From: Simon Davis
Sent: 10 October 2017 09:51
To: Karen Parsons
Subject: FW: FW: BE/71/17/PL - Wickes, Bognor Drainage Scheme

From: Ismail Laher [REDACTED]
Date: Mon, 9 Oct 2017 at 16:16
Subject: FW: BE/71/17/PL - Wickes, Bognor Drainage Scheme

Our responses to Paul Cann of Arun Council are as follows:

| <b>15-112 / 500</b> | <b>P3</b> |

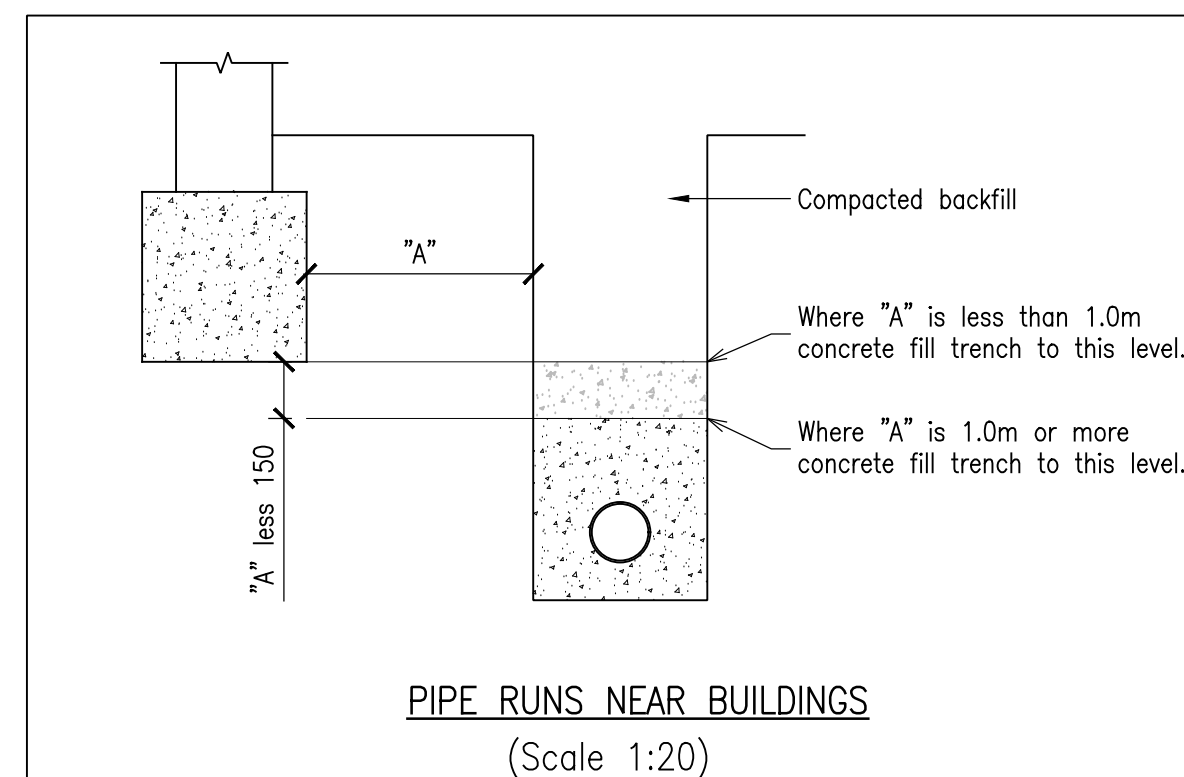
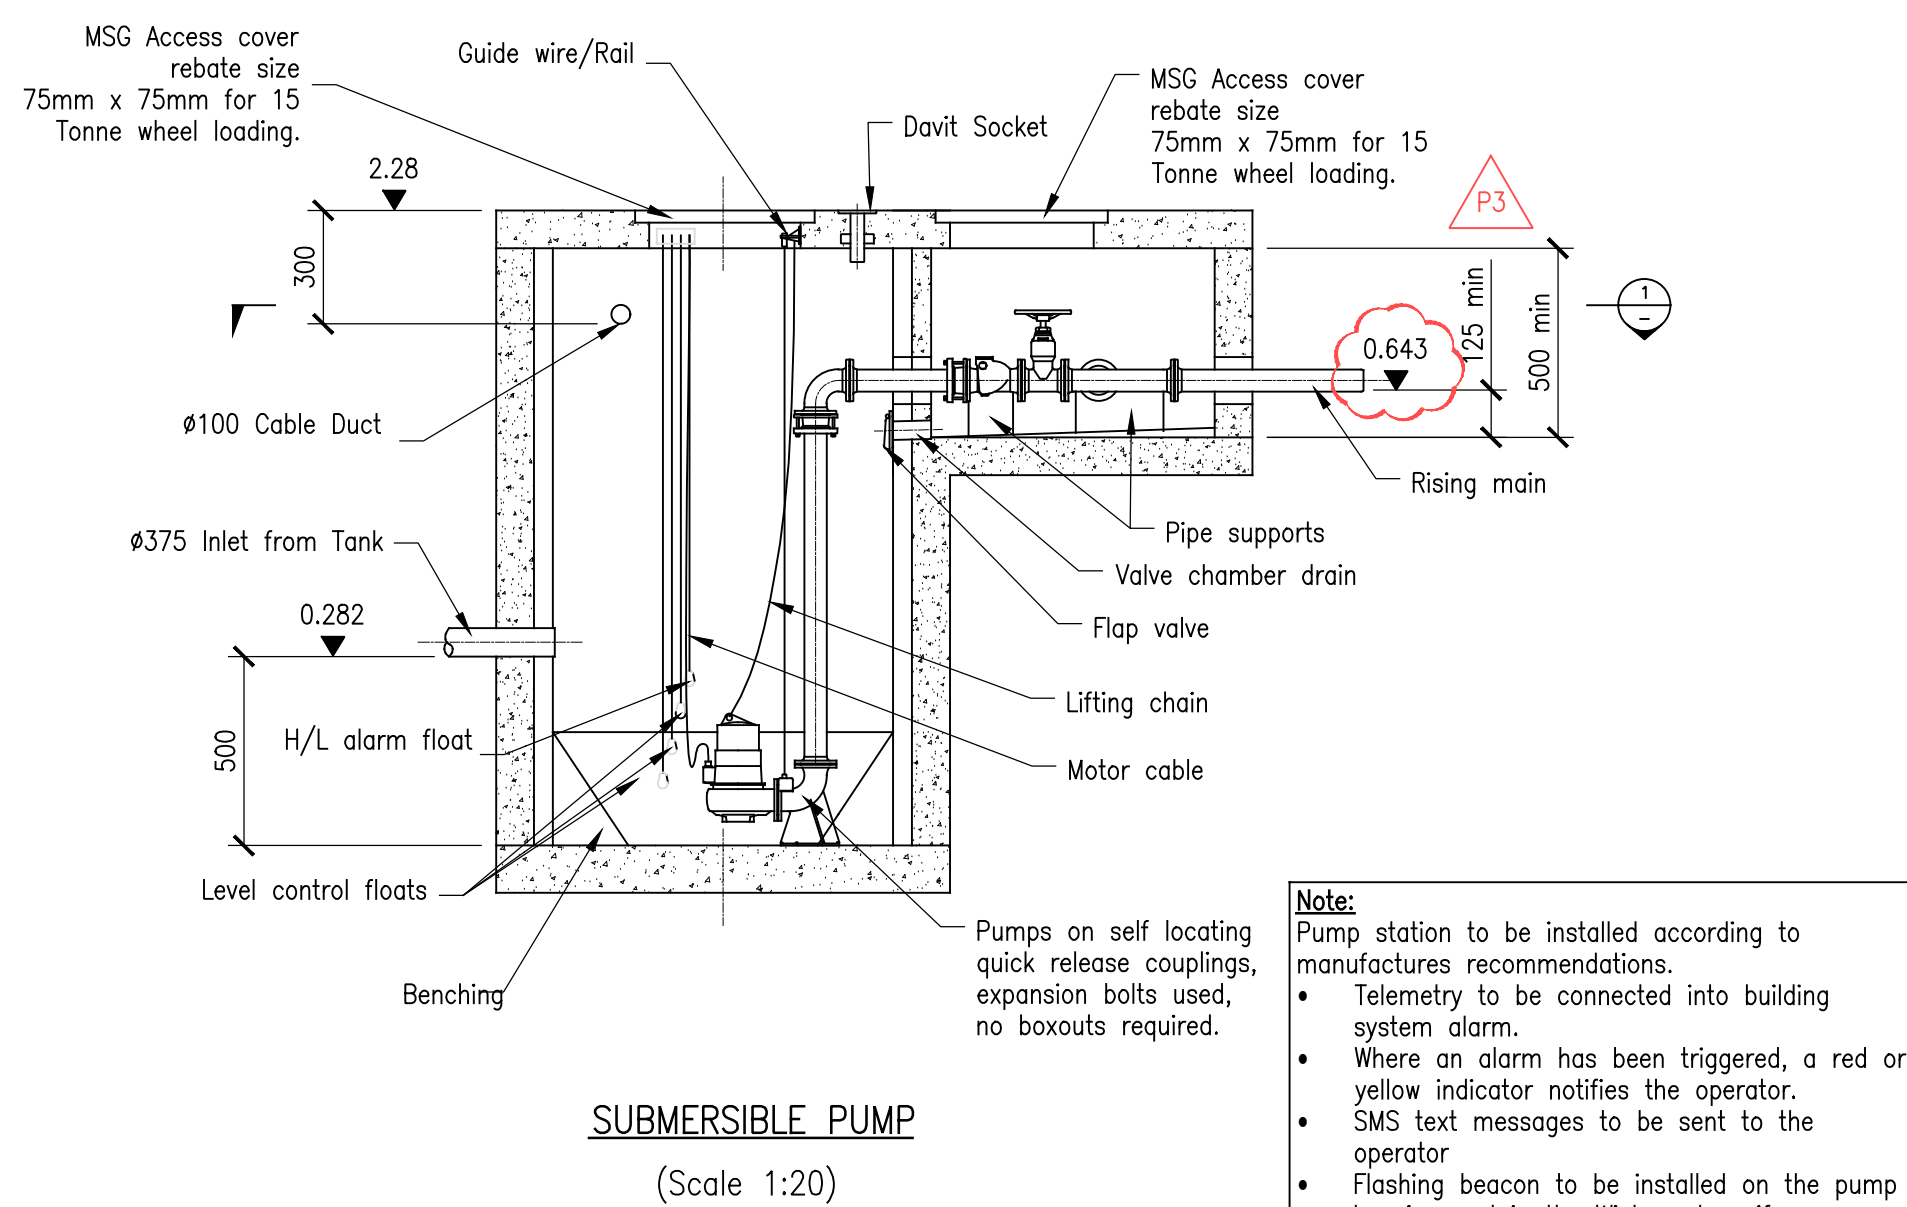
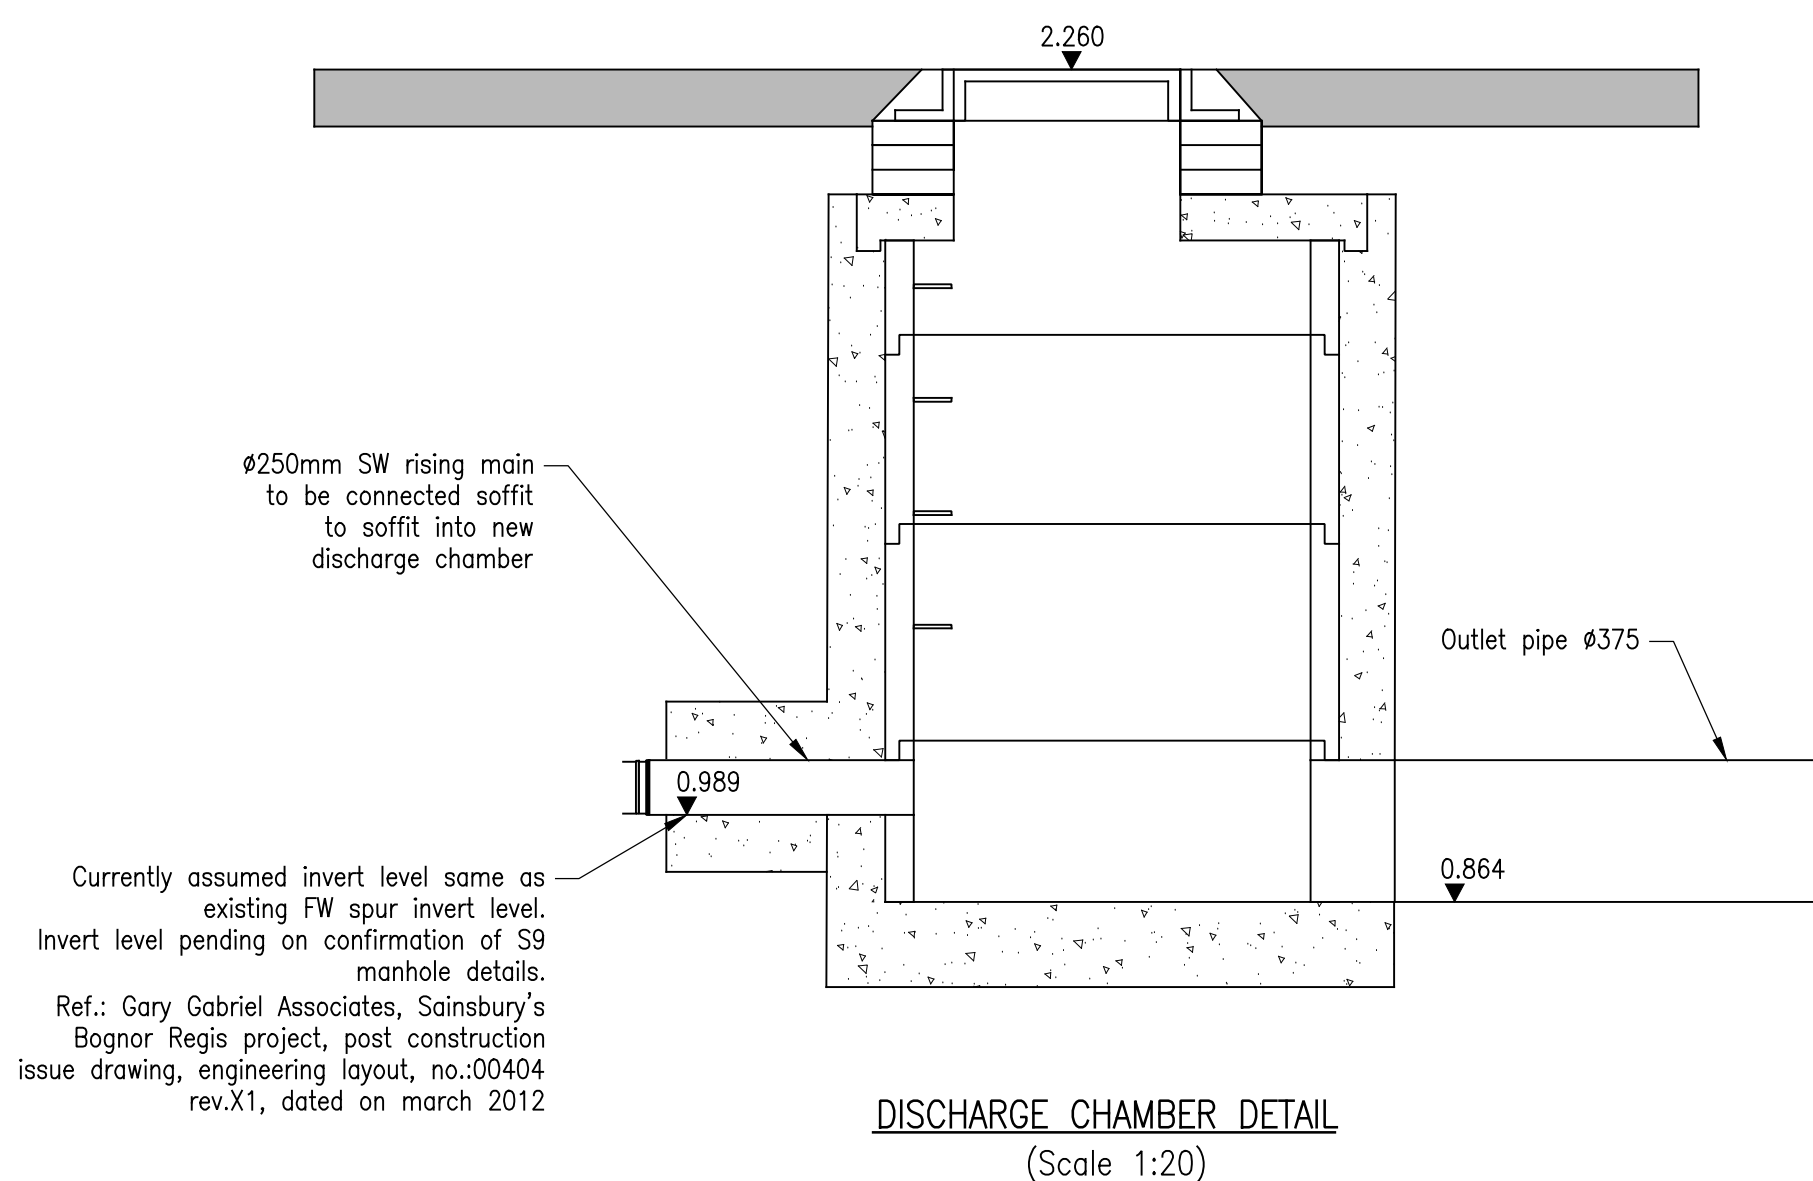
3. The construction detail for the discharge chamber refers to existing manhole S9 and a 450mm outlet pipe. This is not the case. It should show a 250mm diameter rising main with a 375mm diameter outlet. There are some spelling errors too.

Amended to illustrate correct diameters as attached 500P3

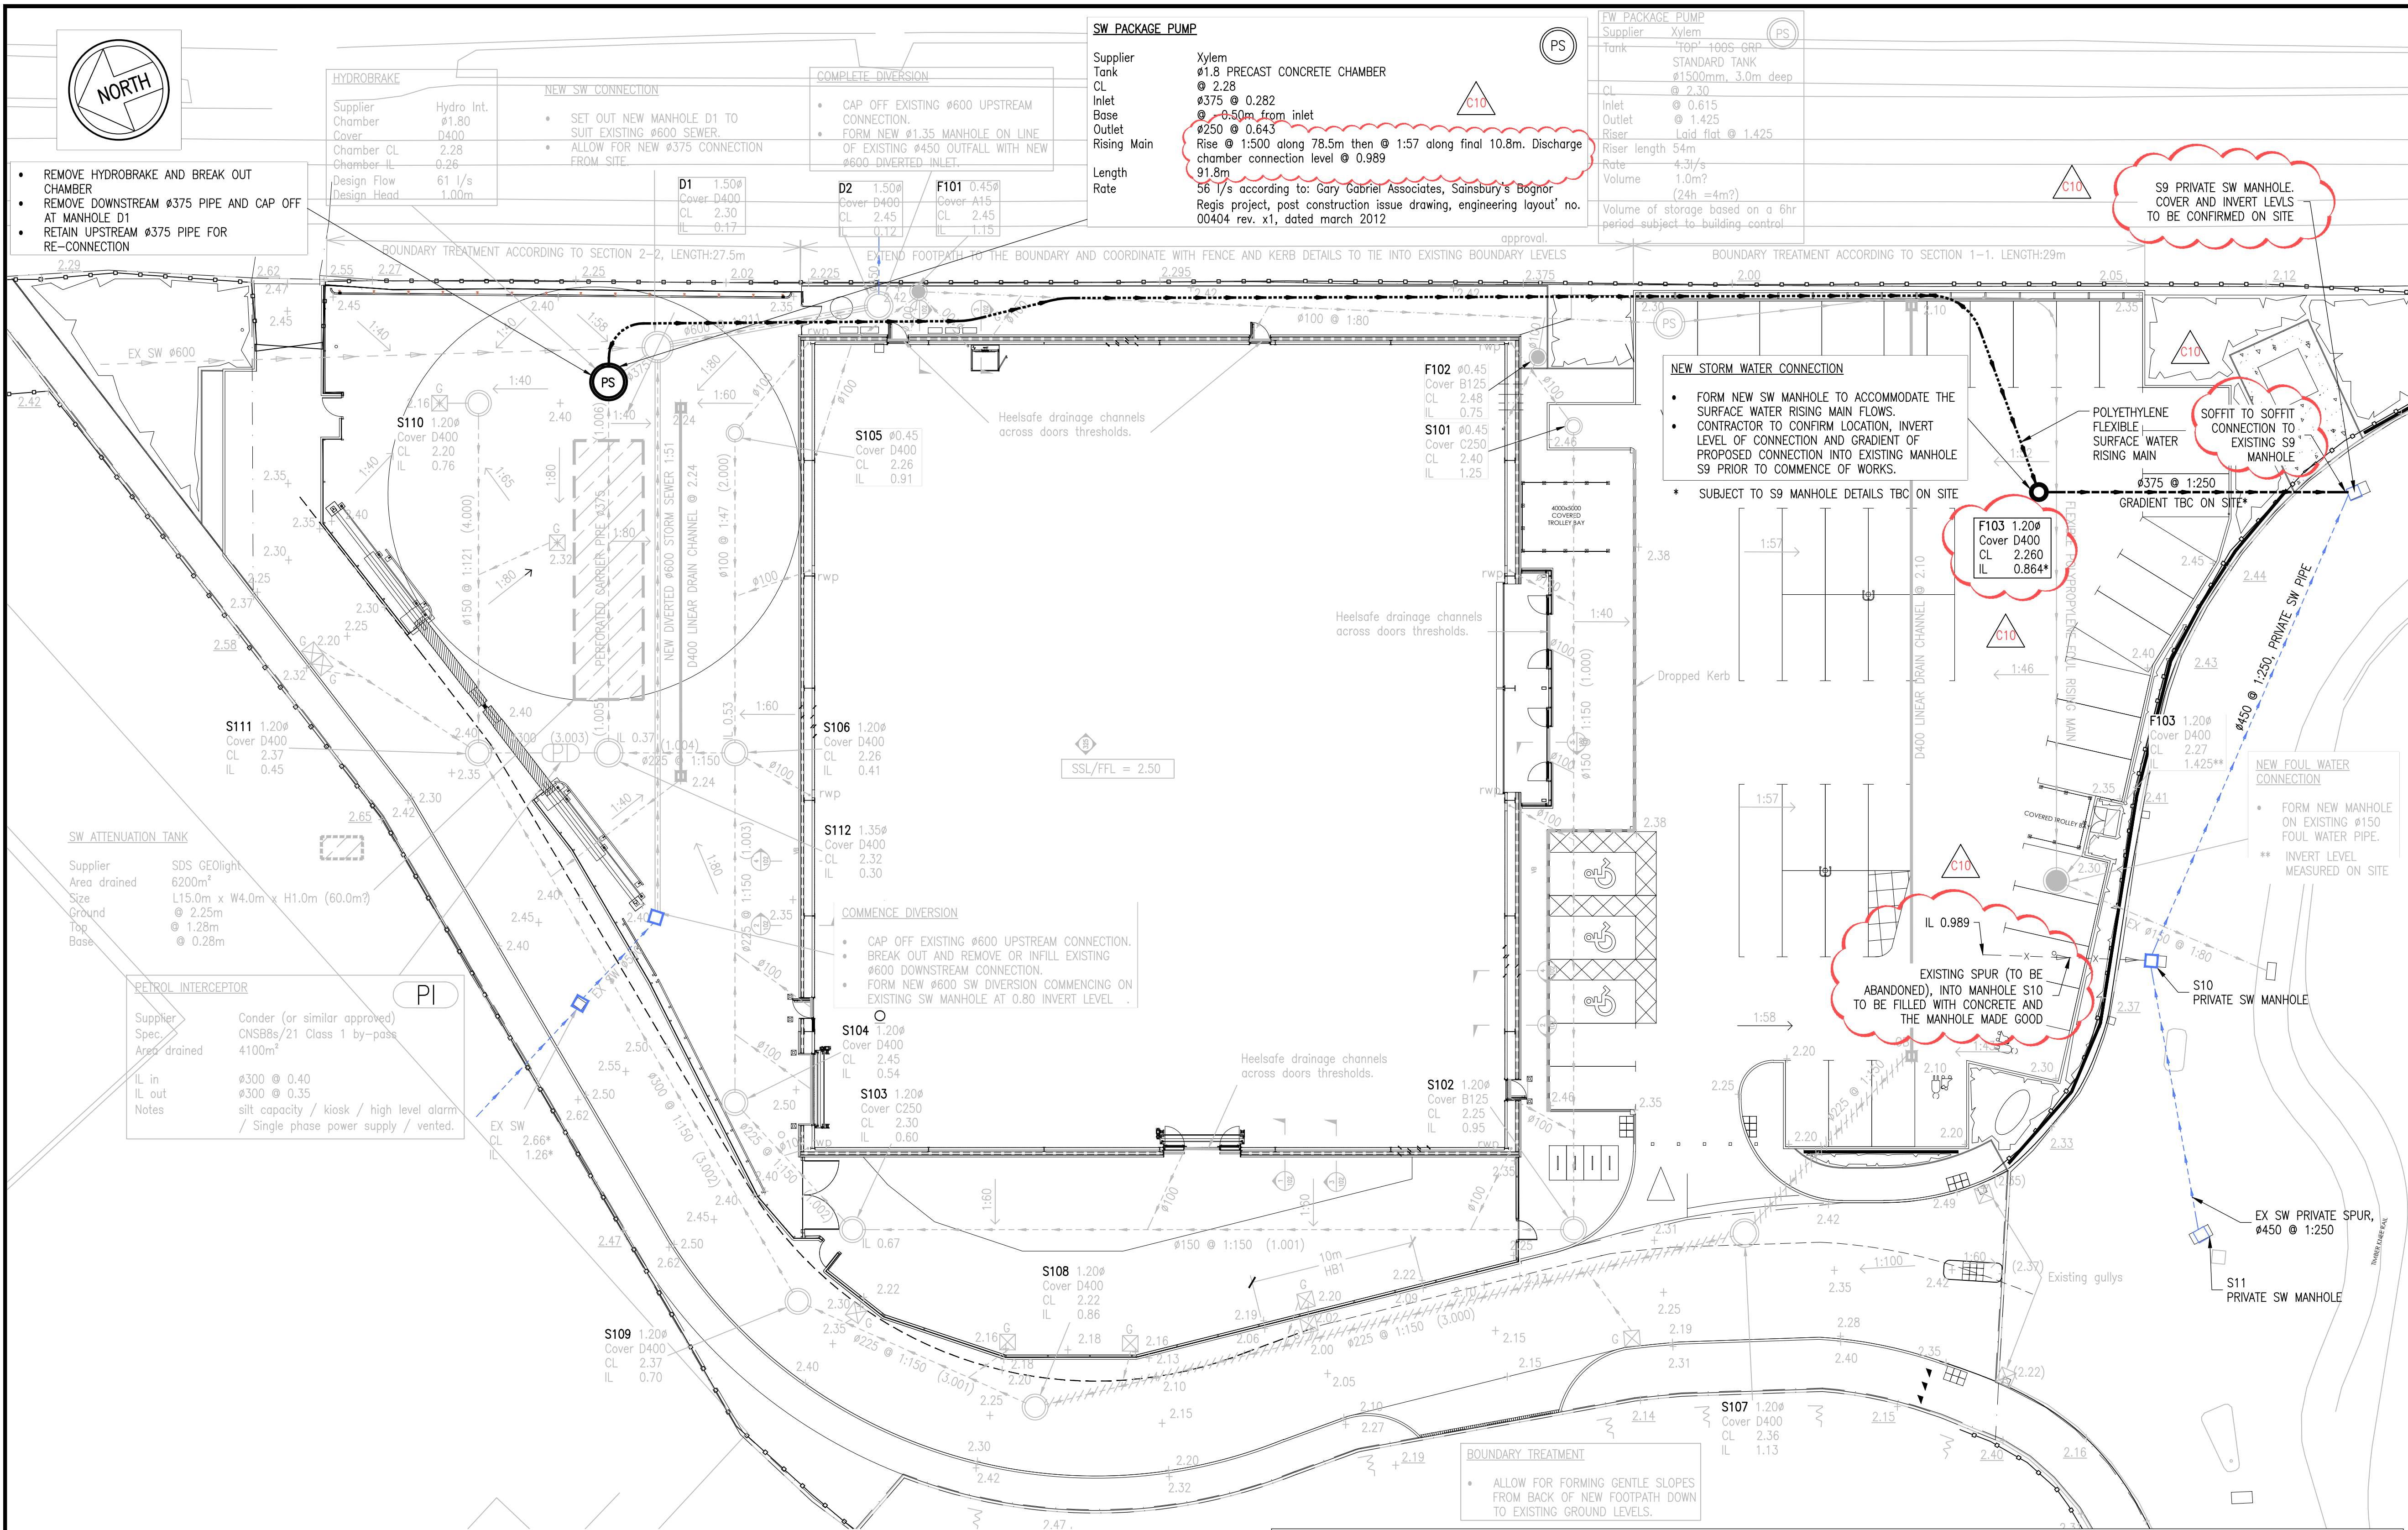
2. Specify invert levels in discharge chamber. Ie. 0.989 if intending to lay it flat, as per notes? A gradual rise would be preferred though.

4. Improve angle of discharge of the rising main into the discharge chamber ie. not 90 degrees.

5. Existing spur (to be abandoned) into manhole S10 to be filled with concrete and the manhole made good. Add note.

Amended to illustrate a gradual rise as attached 300C10

Amended as attached 300C10

Amended as attached 300C10
